Sent: 11 November 2013 21:43
To: Planning
Subject: Welwyn Hatfield Council Online Planning - Comment

Application Number: N6/2013/1938/MA
Name: Welwyn Garden City Society
Address: c/o 125 Daniells
Welwyn Garden City AL7 1QT
Comment Type: Object
Comment: APPLICATION REFERENCE N6/2013/1938/MA PROPOSED COUNCIL OFFICE EXTENSION (AMENDED PLANS) AN OBJECTION ON BEHALF OF THE WELWYN GARDEN CITY SOCIETY

Title Proposed Entrance to
Council Chamber
Detail Drawing

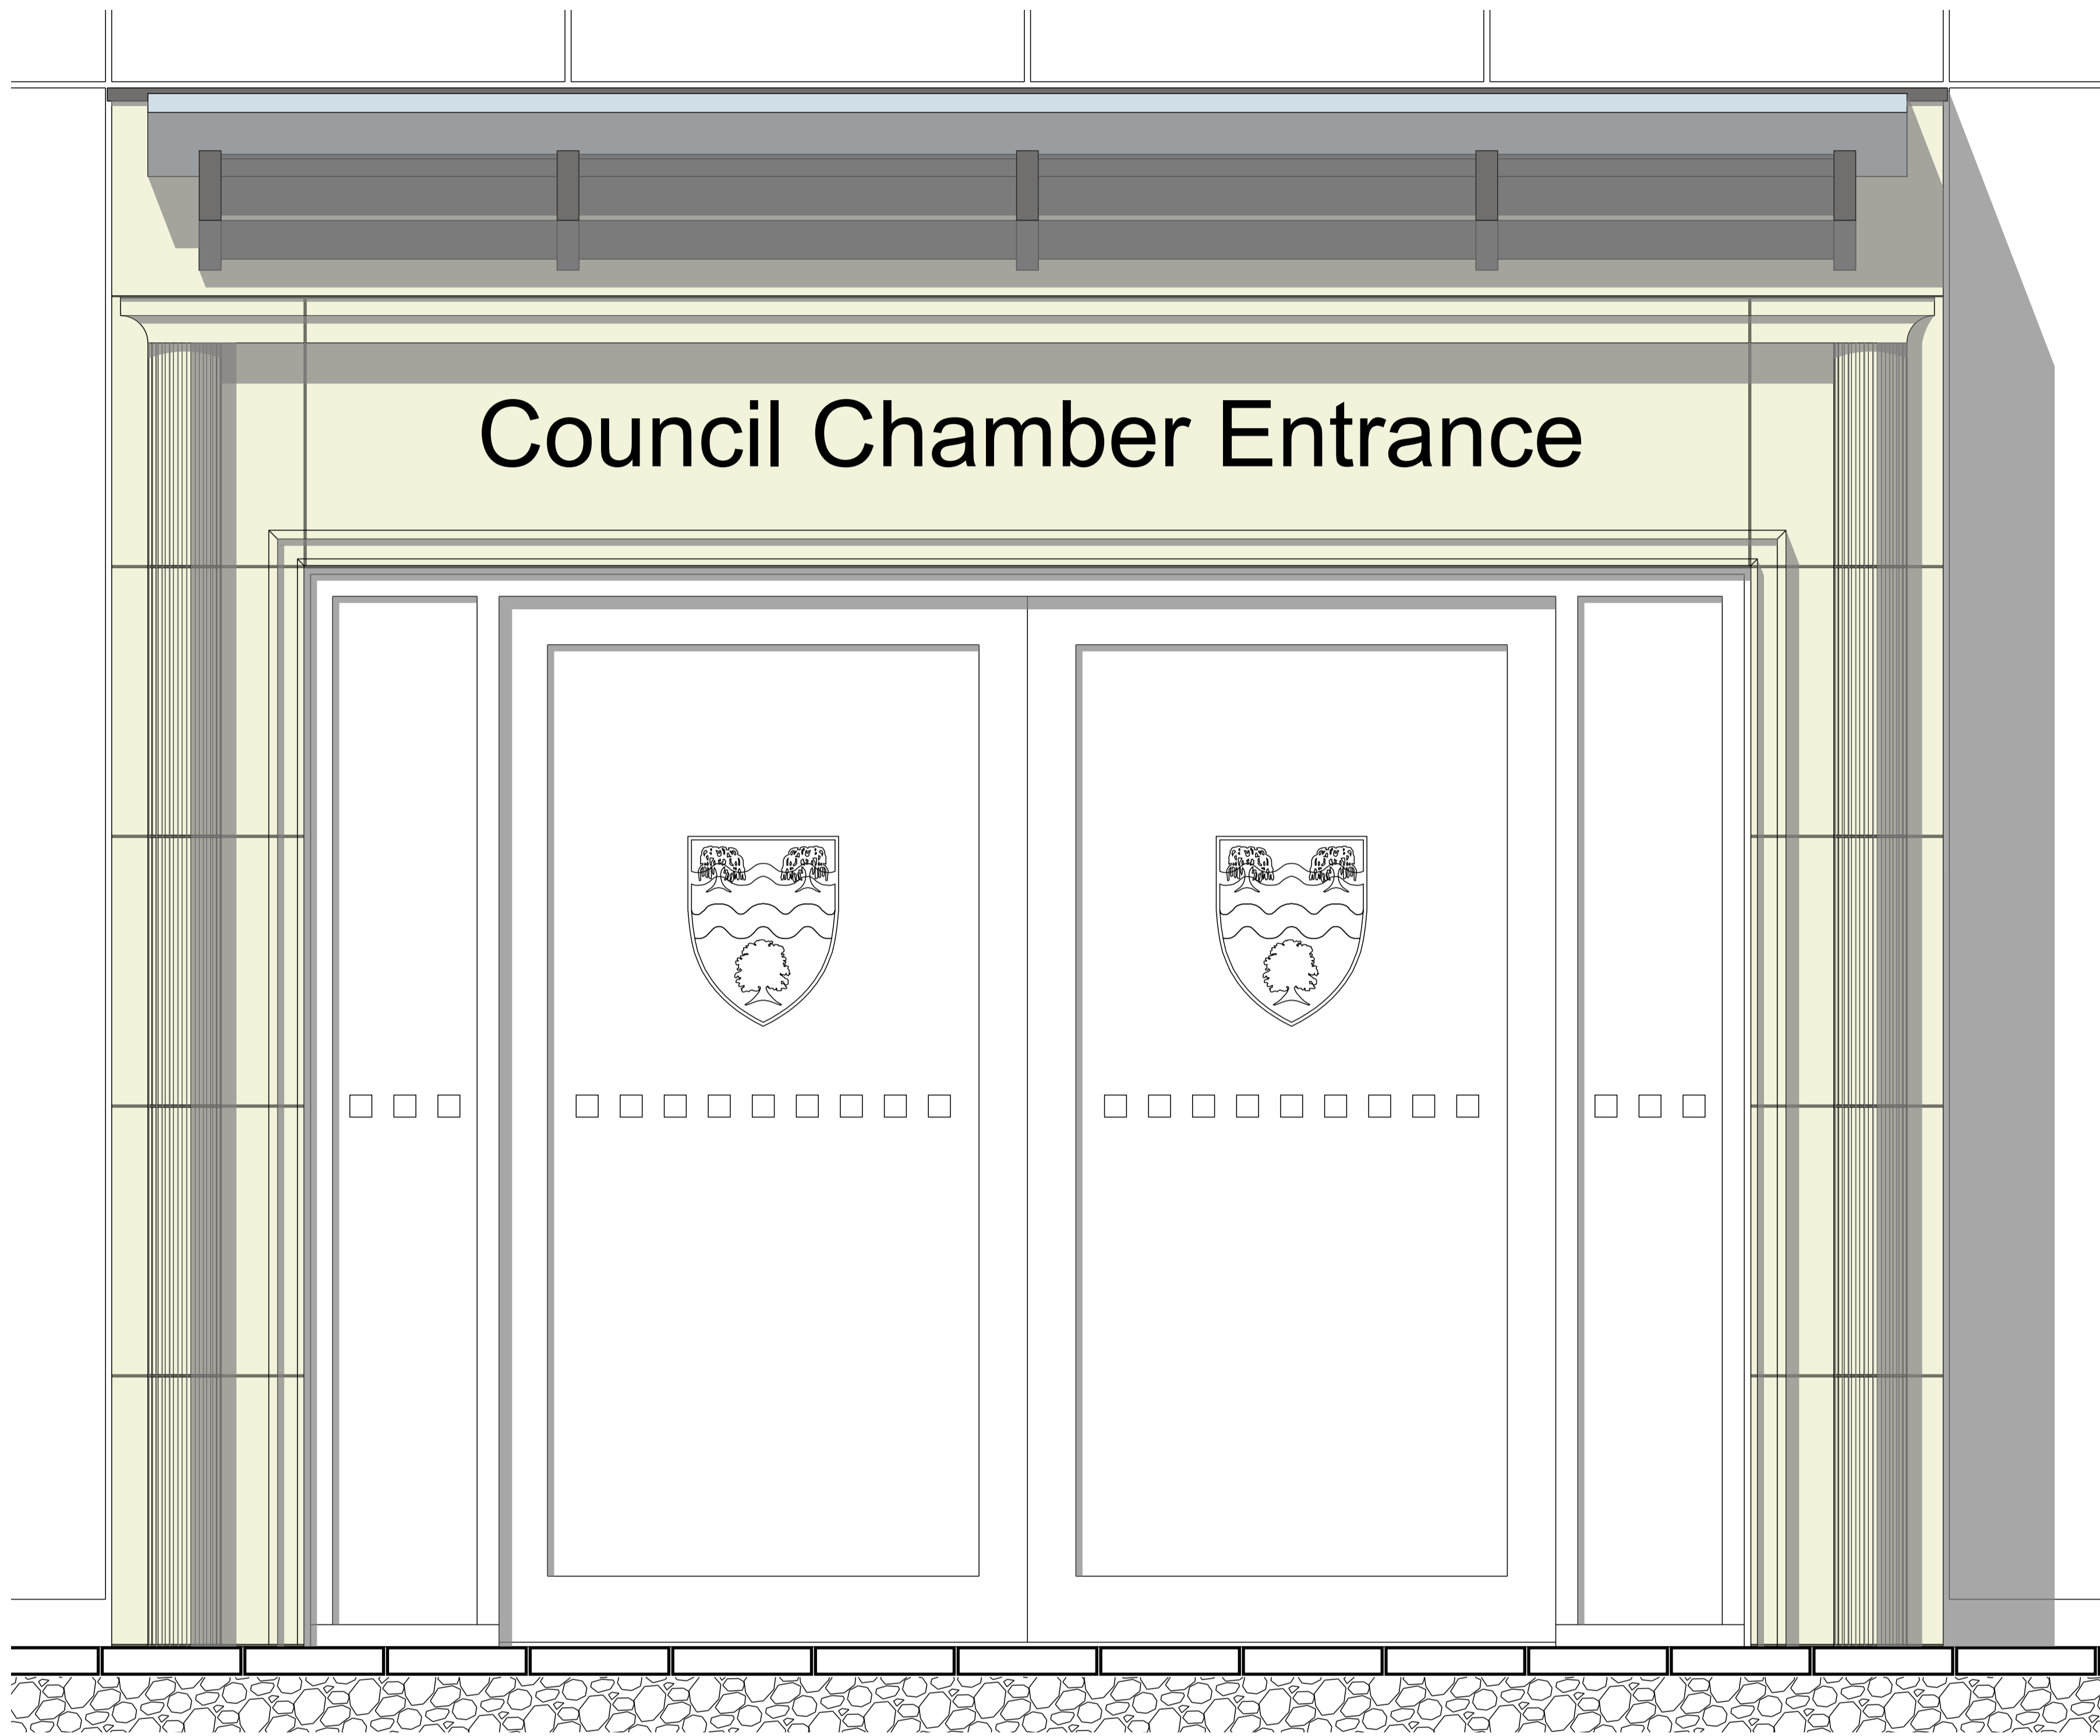
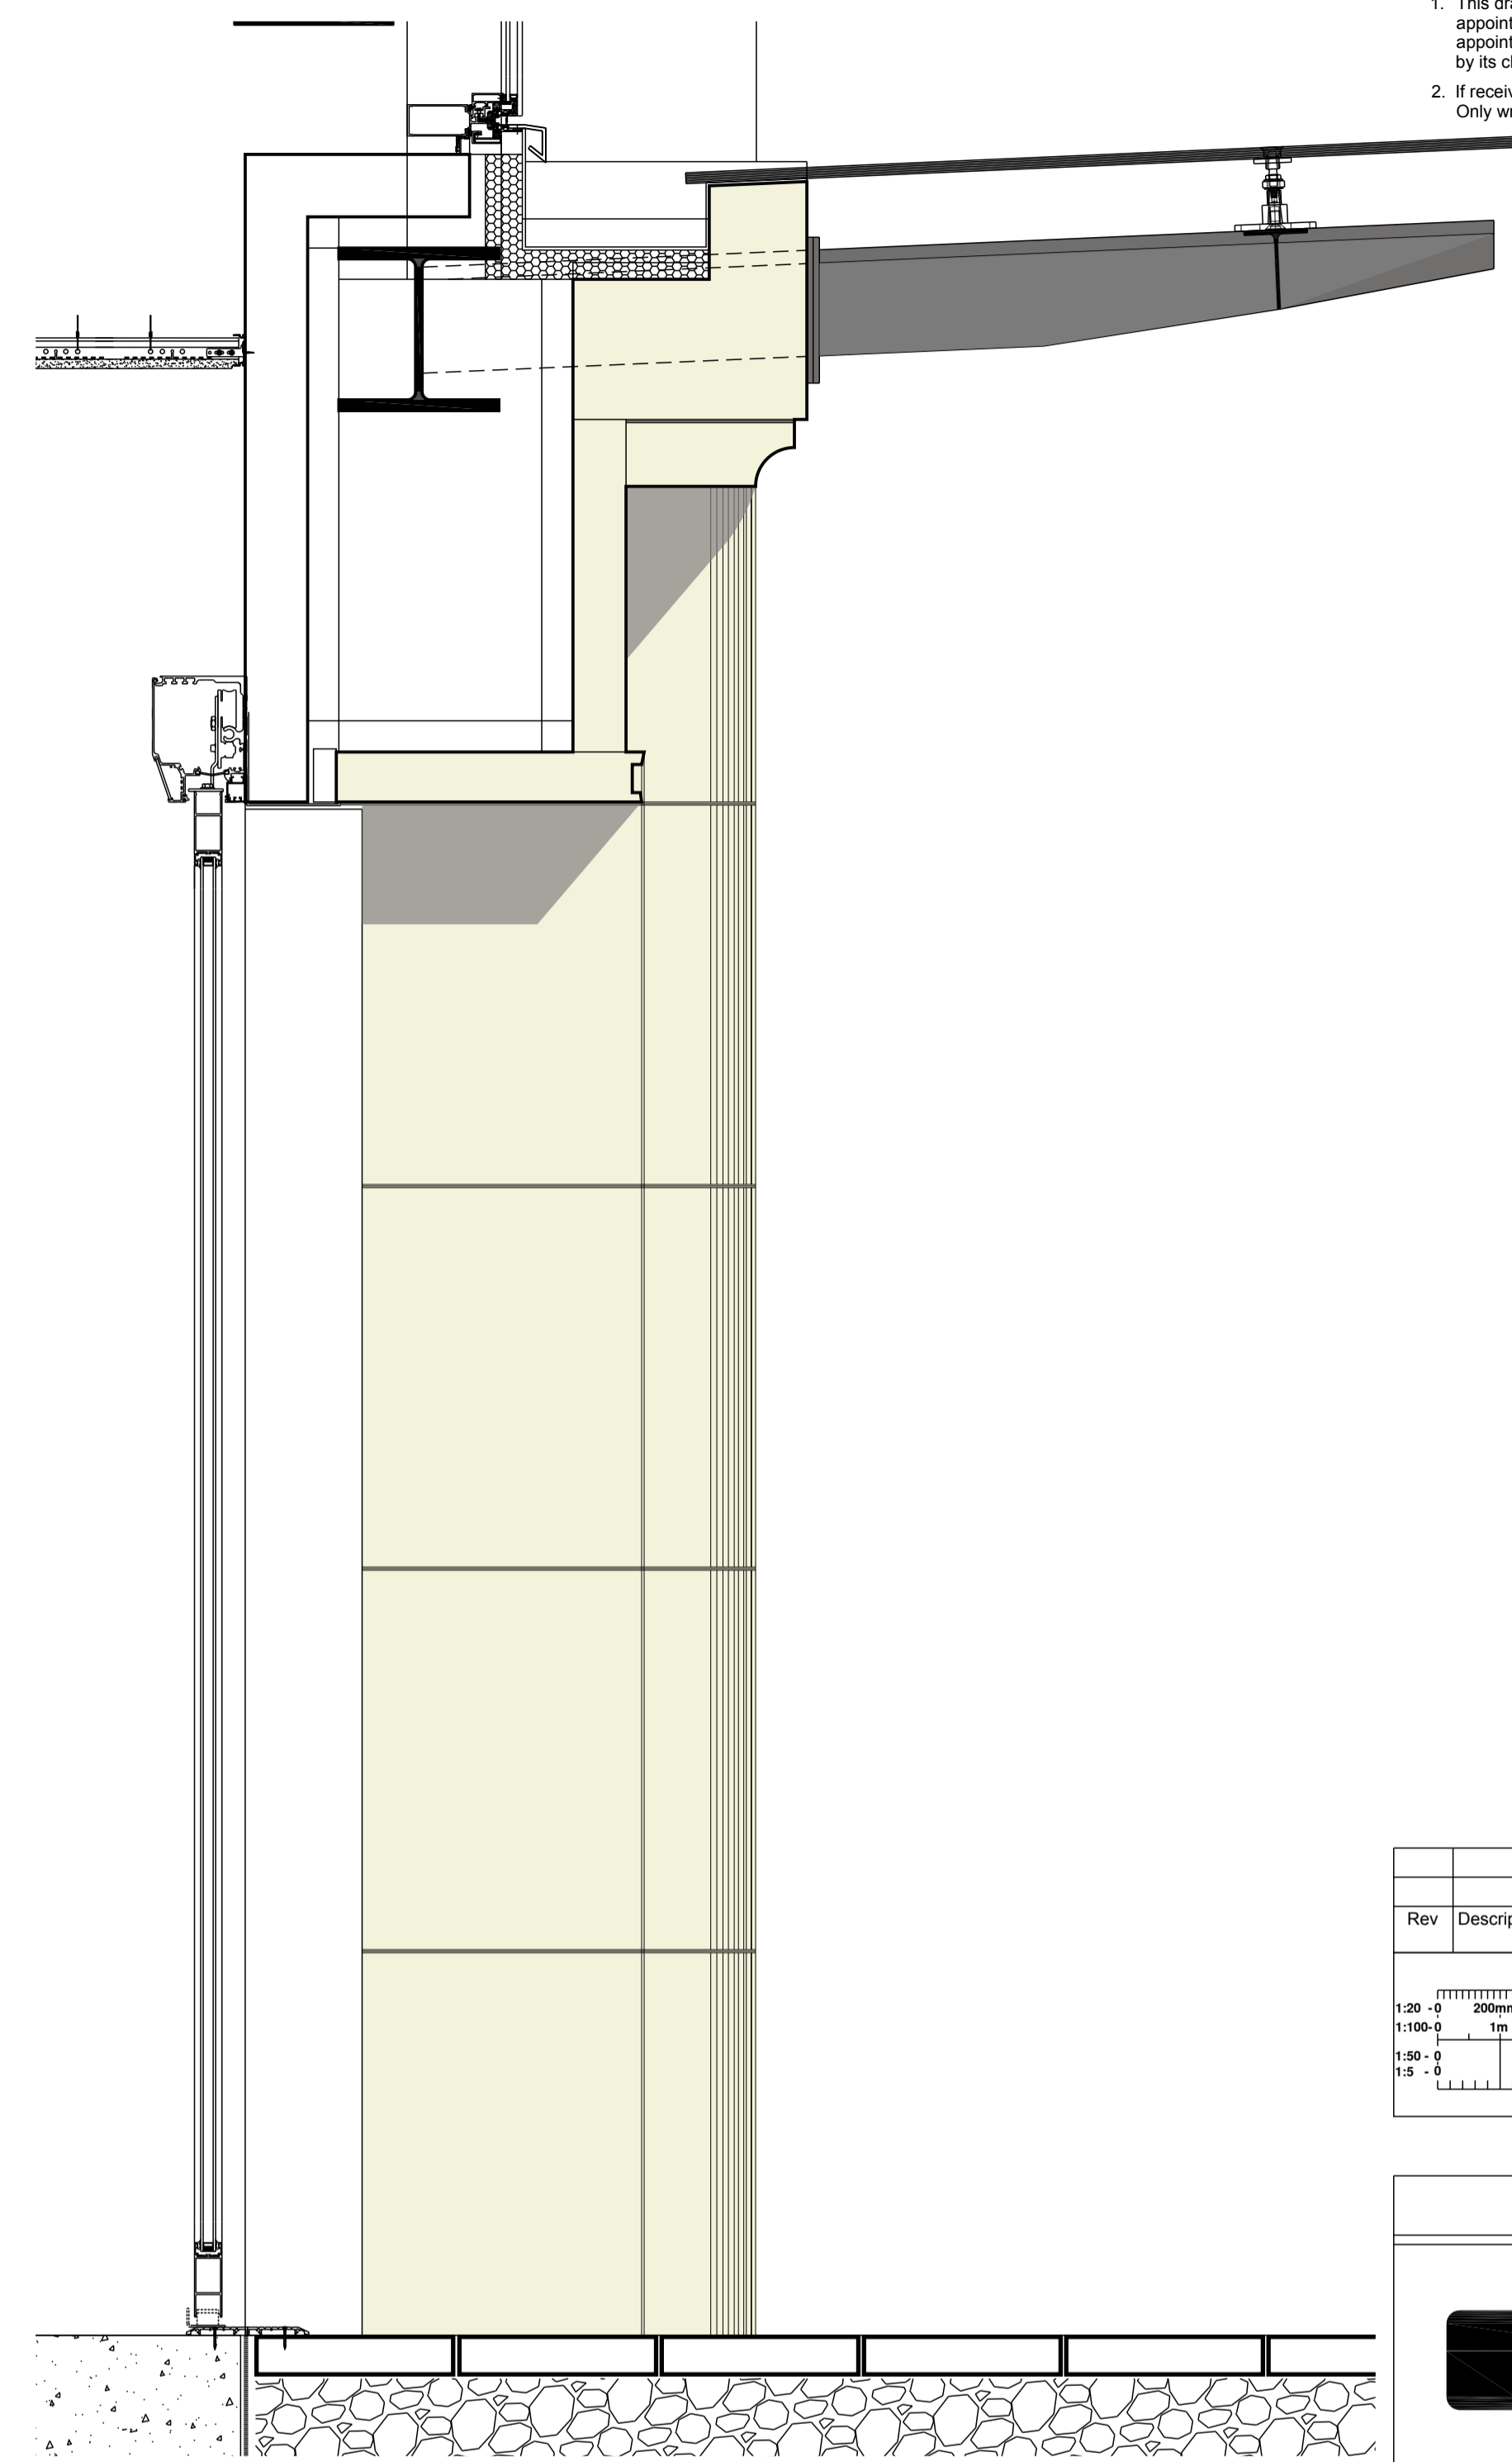
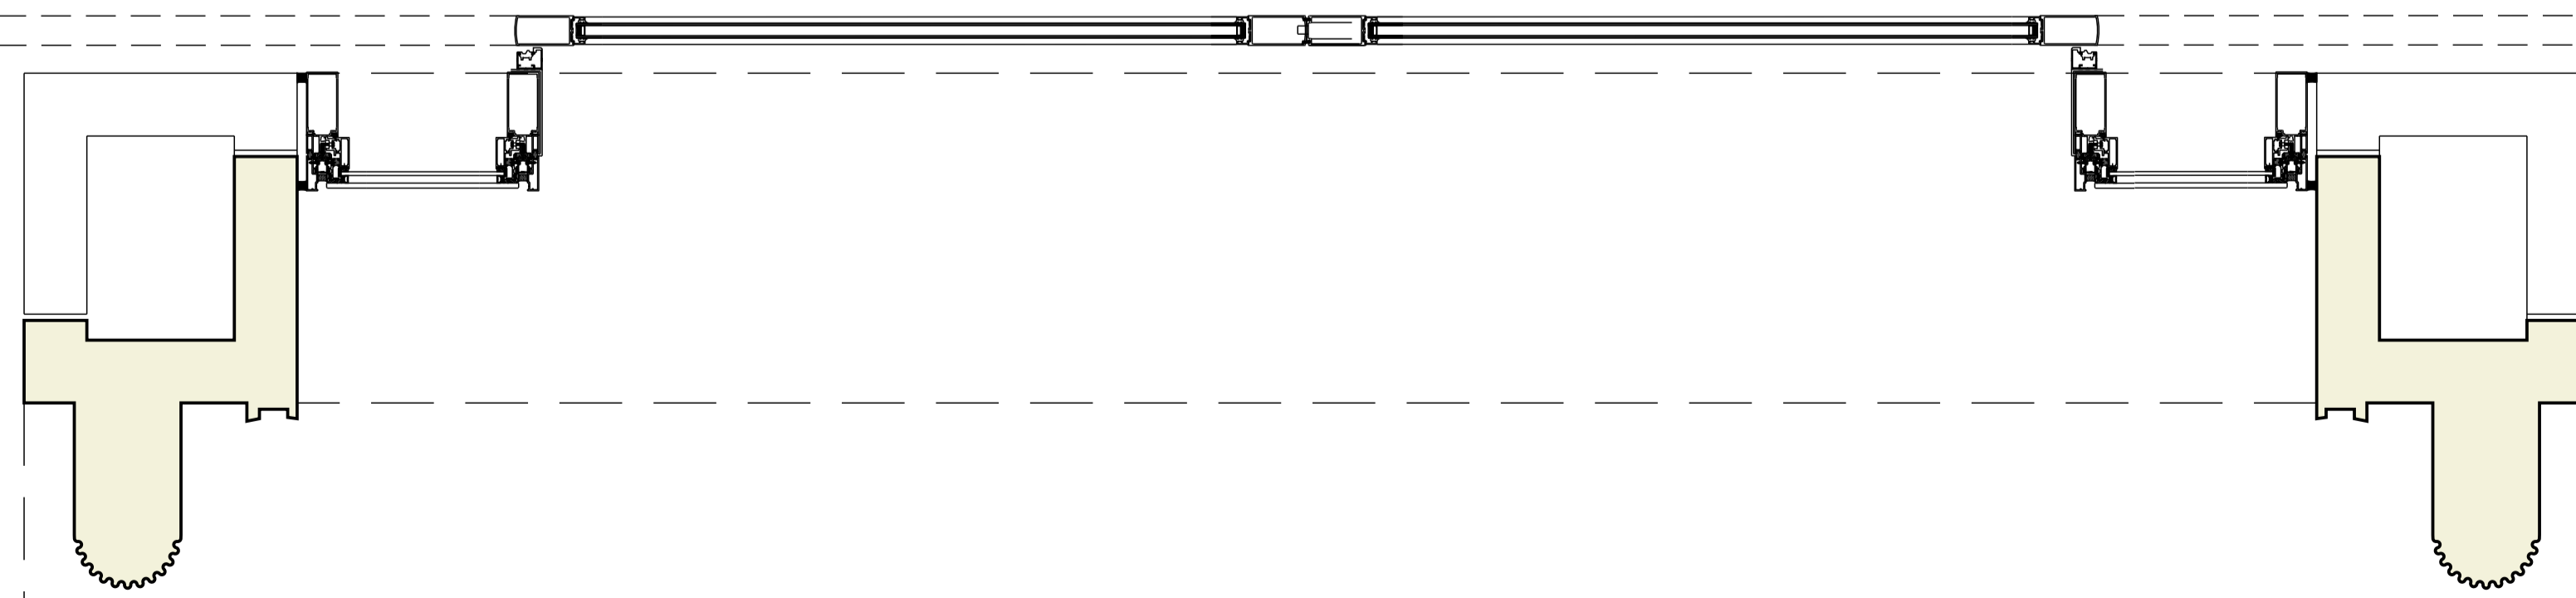
The revision to make the glass facade vertical and to alter the plan profile of the frame; to create the illusion that it is slimmer is unsuccessful, while the new portico is both larger and a more dominant element than the original scheme, copying the detail of the main entrance is without merit.

Whether intended or not, this latest addition, even with the caption over the door of 'Council Chamber Entrance', has all the pretensions of being the principal facade and thus the entrance to the council offices. However, it is in fact a Staff Entrance / Exit at the rear of the building, and a public entrance only for the Council Chamber space. Therefore, the proposal creates two, likely to be confused, front entrances. The proposed landscaping only reinforces this with its tree and shrub-lined, paved, processional route up to doors that are completed with, an again currently fashionable, cantilevered glass canopy.
